DELEGATED HOUSEHOLDER DECISION

Item No.	Report of the Head of Planning, Sport and Green Spaces	
Address	43 HARLYN DRIVE PINNER	
Development:	Single storey rear extension and conversion of roof space to habitable use to include a rear dormer with Juliette balcony, 3 front rooflights and conversion of roof from hip to gable end	
LBH Ref Nos:	69719/APP/2014/257	
Drawing Nos:	Location Plan EXISTING ELEVATIONS EXISTING FLOORPLAN EXISTING SECTIONS PROPOSED FLOOR PLAN Location Plan PROPOSED LOFT PLAN AN REAR ELEVATION PROPOSED SECTION PROPOSED ELEVATION	
Date Plans Received:	27/01/2014	Date(s) of Amendment(s):
Date Application Valid:	28/01/2014

Proposed Ground Floor Plan

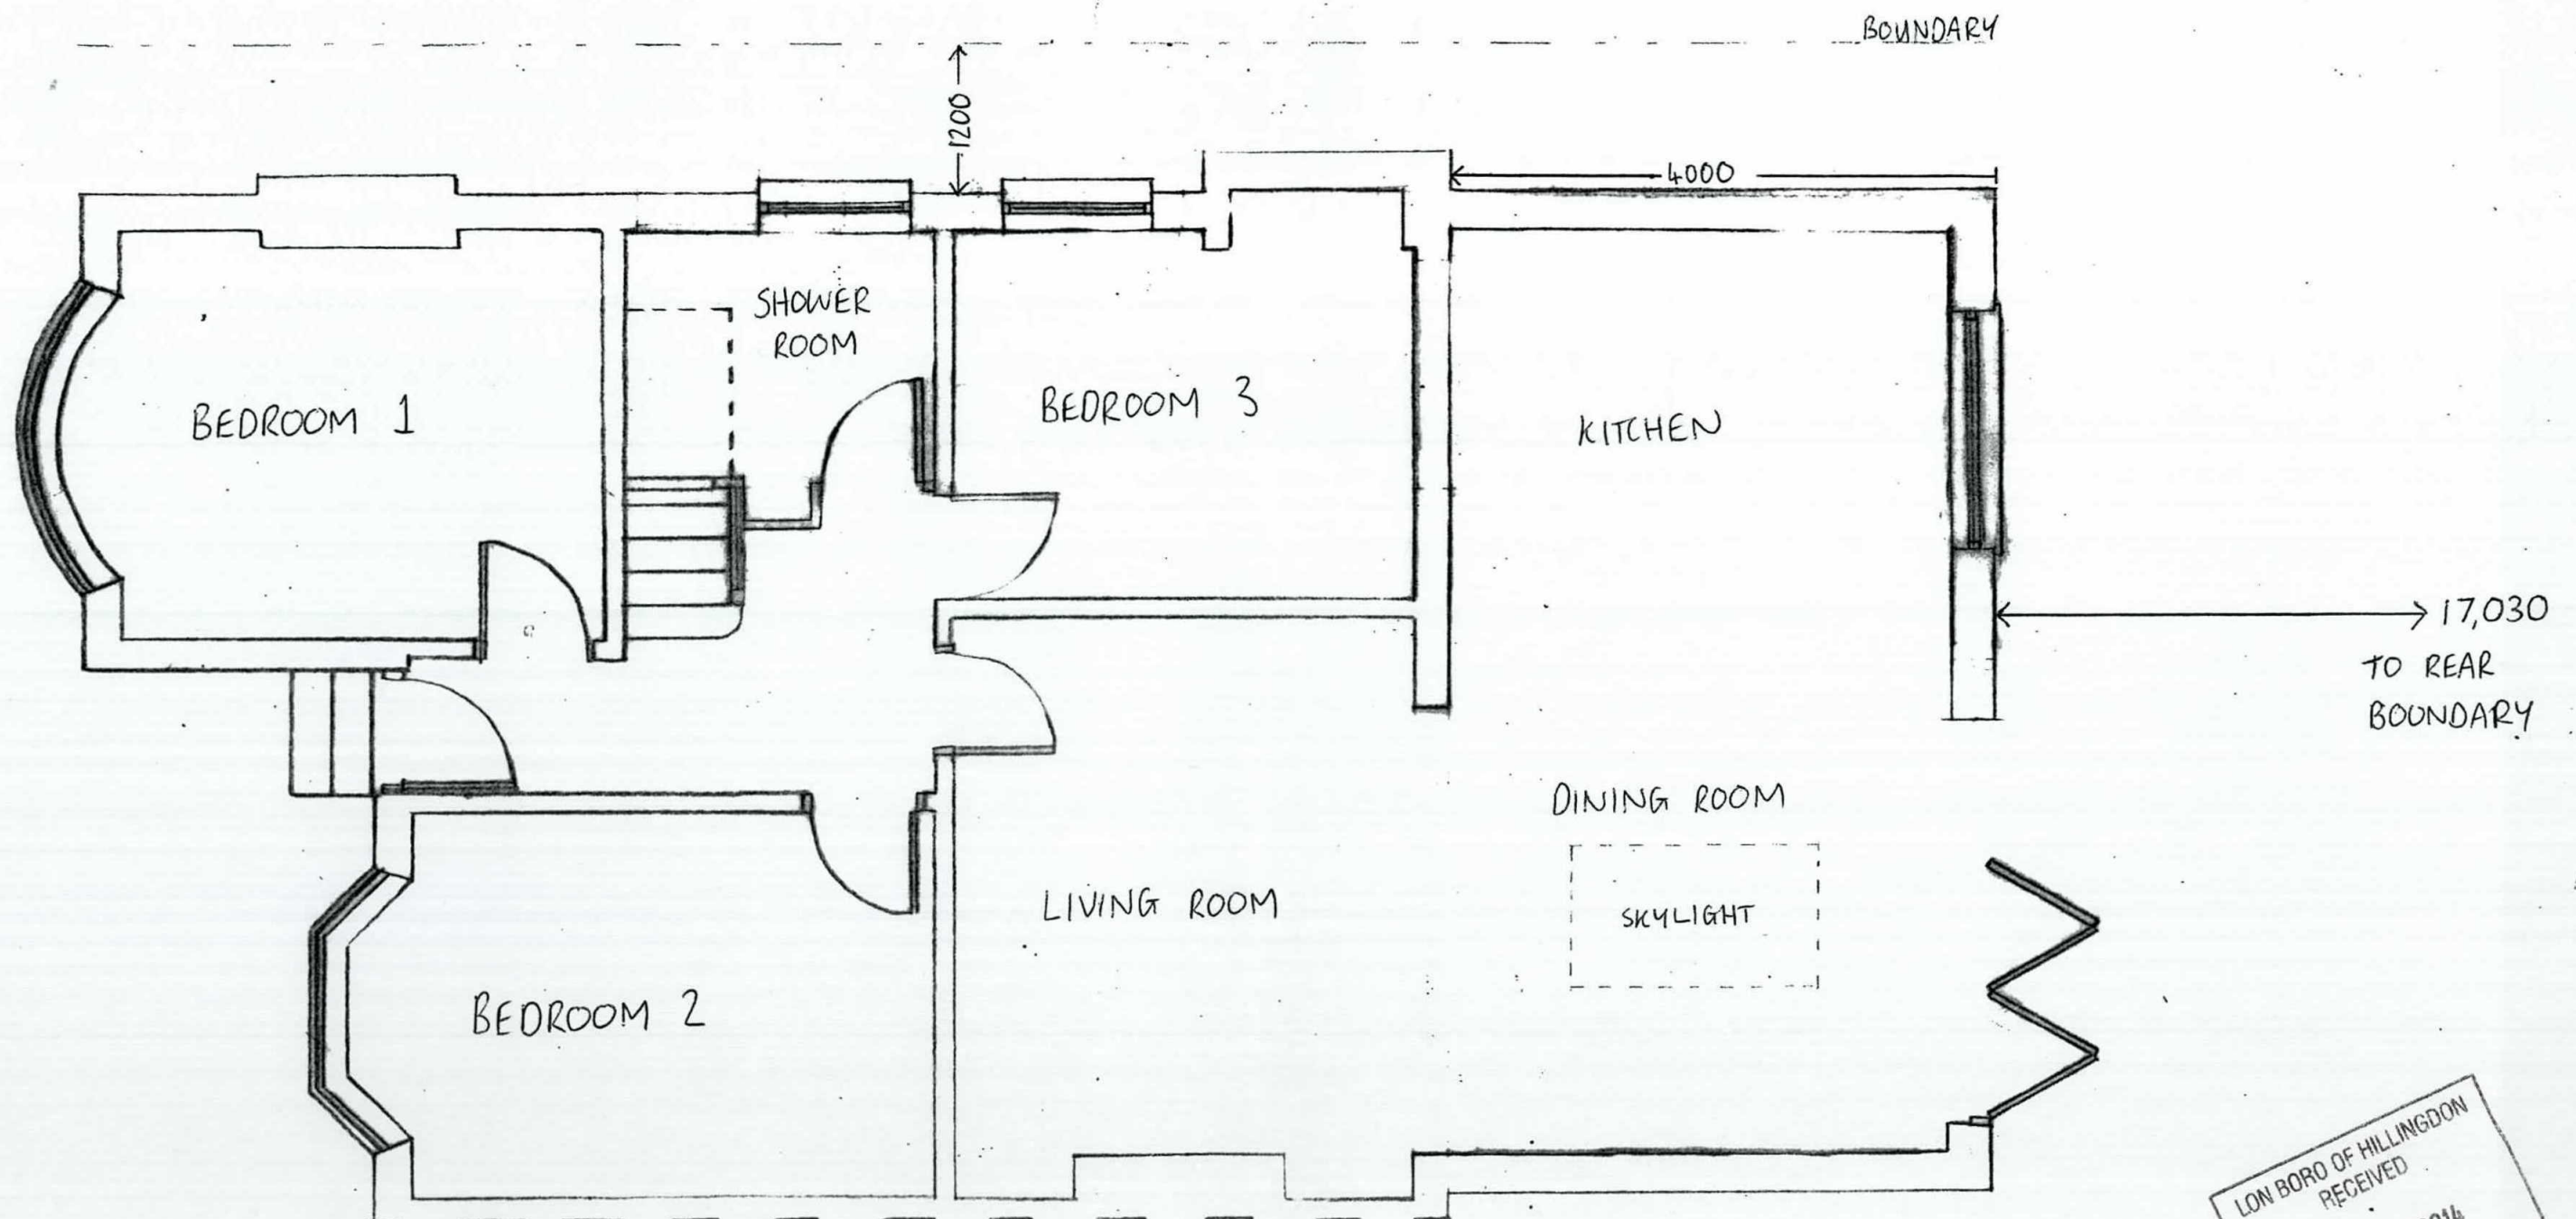
The depth and height of the proposed single storey rear extension would not be consistent with those as set out in paragraphs 3.3 and 3.7 of the HDAS: Residential Extensions. This guidance advises that extensions to semi detached properties should be a maximum of 3.6m deep and 3m high with a flat roof. The proposed extension is 4m deep and 3.3m high. The single storey rear extension, by reason of its scale, form and design would therefore not appear subordinate to the original house and would not harmonise satisfactorily with its character and appearance. It is noted that the adjacent properties are set forward of the building line of the proposed application property, however, this is not seen on its own as an issue of concern. Therefore, the single storey rear extension would detract from the visual amenities of the surrounding area and would not be in compliance with policies BE13, BE15 and BE19 of the Hillingdon Local Plan: Part Two - Saved Policies (November 2012) and section 3.0 of the Hillingdon Design & Accessibility Statement (HDAS): Residential Extensions.

The rear windows and door proposed to the extension would provide an adequate outlook and natural light to the room they would serve. The proposal also provides for the internal conversion of a bathroom and cloakroom to a small bedroom. This requires the provision of a larger window which could not be obscured glazed. The bedroom would be 1.1m off the boundary of the property with No. 39 and whilst it is not considered that this will lead to unsatisfactory overlooking it will have limited outlook and daylight / sunlight making it an unsatisfactory living environment. Therefore, the proposal is contrary to policy BE20 of the Hillingdon Local Plan Part 2 Saved Policies (November 2012) and guidance in HDAS Residential Extensions.

The proposed scheme provides an additional 2 bedrooms which would normally require 2 of street parking spaces. Currently there is space to the front of the property to just fit two cars but this space would not comply with parking space standards of 4.8m x 2.4 each and therefore it is considered that it has not been proven that this is satisfactory for the enlarged property. As such the proposal is contrary to policy AM14 of the Hillingdon Local Plan Part 2 Saved Policies (November 2012).

The proposed ground floor bedroom would be served by a single window which is sited 1m off the boundary fence with No. 39 Harlyn Drive and as such would provide an unsatisfactory outlook and level of daylight to the bedroom, leading to the provision of an unsatisfactory residential living environment. The proposal would be contrary to policy BE20 of the Hillingdon Local Plan Part 2 Saved Policies (November 2012) and the adopted Supplementary Planning Document HDAS: Residential Extensions.

The proposed development does not demonstrate the provision for two off street car parking spaces to serve the enlarged 4 bedroom property. As such the proposed development would lead to demand for on street parking which would not be in the interest of highway safety. Therefore, the proposal would not comply with policy AM14 of the Hillingdon Local Plan Part 2 Saved Policies (November 2012).

Proposed Front Elevation

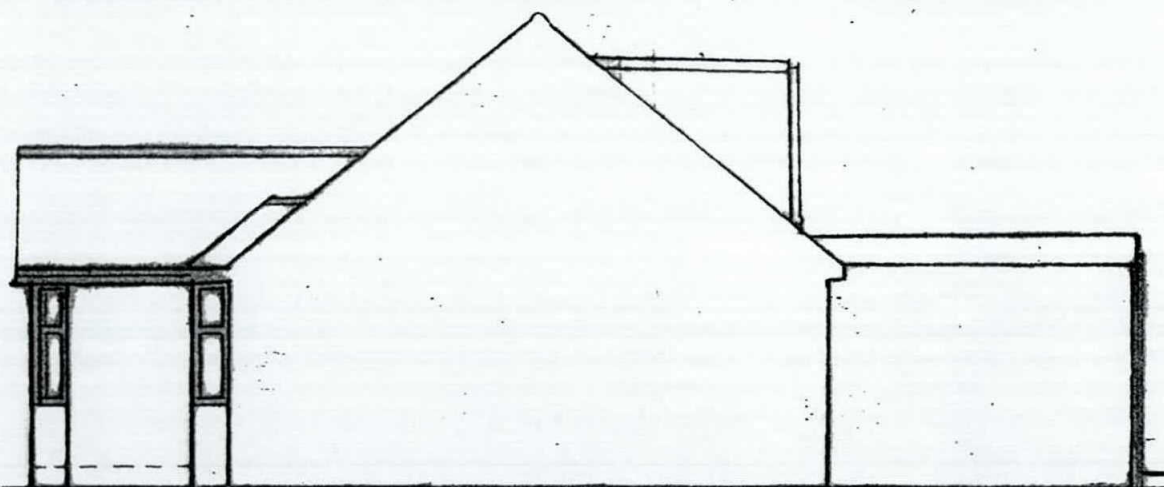
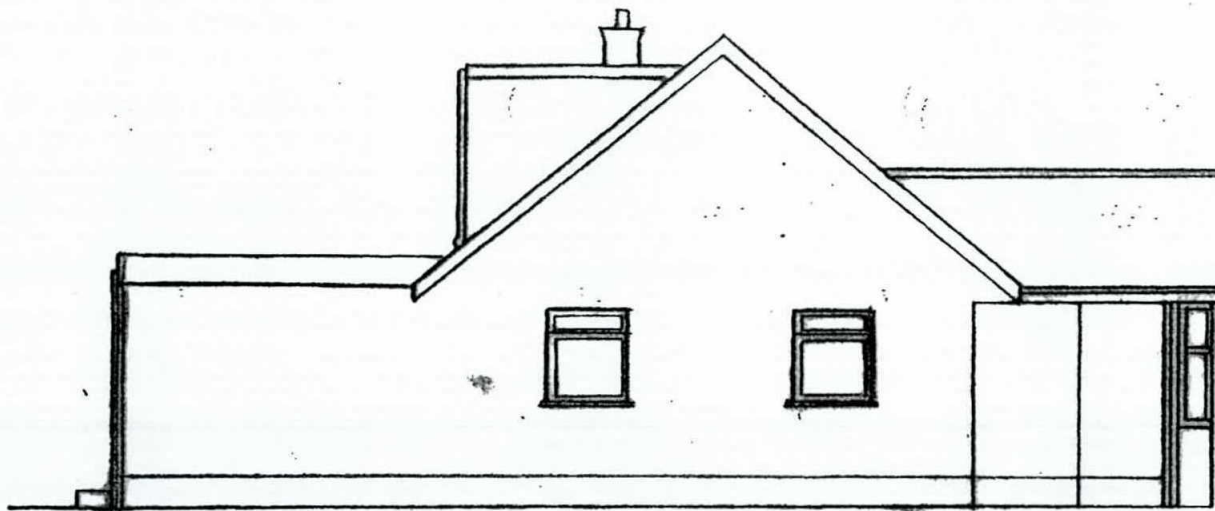
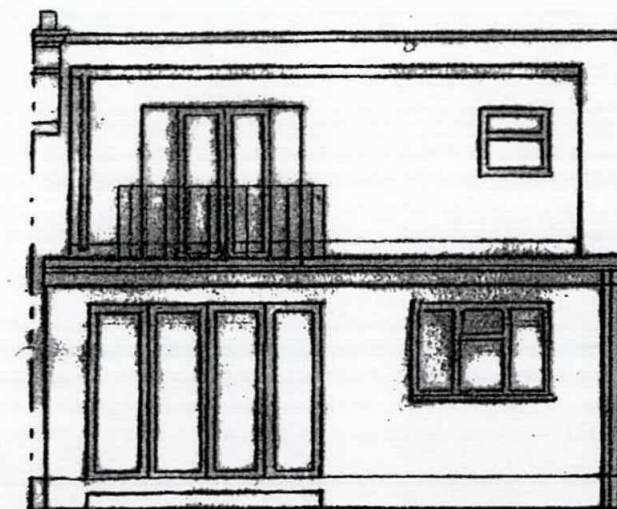
The proposed dormer extension would be viewed from neighbouring rear gardens and also from the school. The overall size, scale, bulk and design of the rear dormer is considered to comply with guidance in HDAS chapter 7. Whilst paragraph 7.11 advises that hip to gable extension would normally be refused the current proposal would constitute permitted development as it is less than 50 cubic metres additional space and meets the the other criteria for such roof extensions. In light of this it is not considered reasonable to refuse planning permission on this ground.

The proposal by reason of the size, scale, bulk, width, height and design of the single storey rear extension represents an unduly intrusive and incongruous form of development, detrimental to the character and appearance of the existing dwelling and the visual amenities of the street scene and the wider area. As such it would be contrary to Policy BE1 of the Hillingdon Local Plan: Part One - Strategic Policies (November 2012), Policies BE13, BE15 and BE19 of the Hillingdon Local Plan: Part Two - UDP Saved Policies (November 2012) and the adopted Supplementary Planning Document HDAS: Residential Extensions.
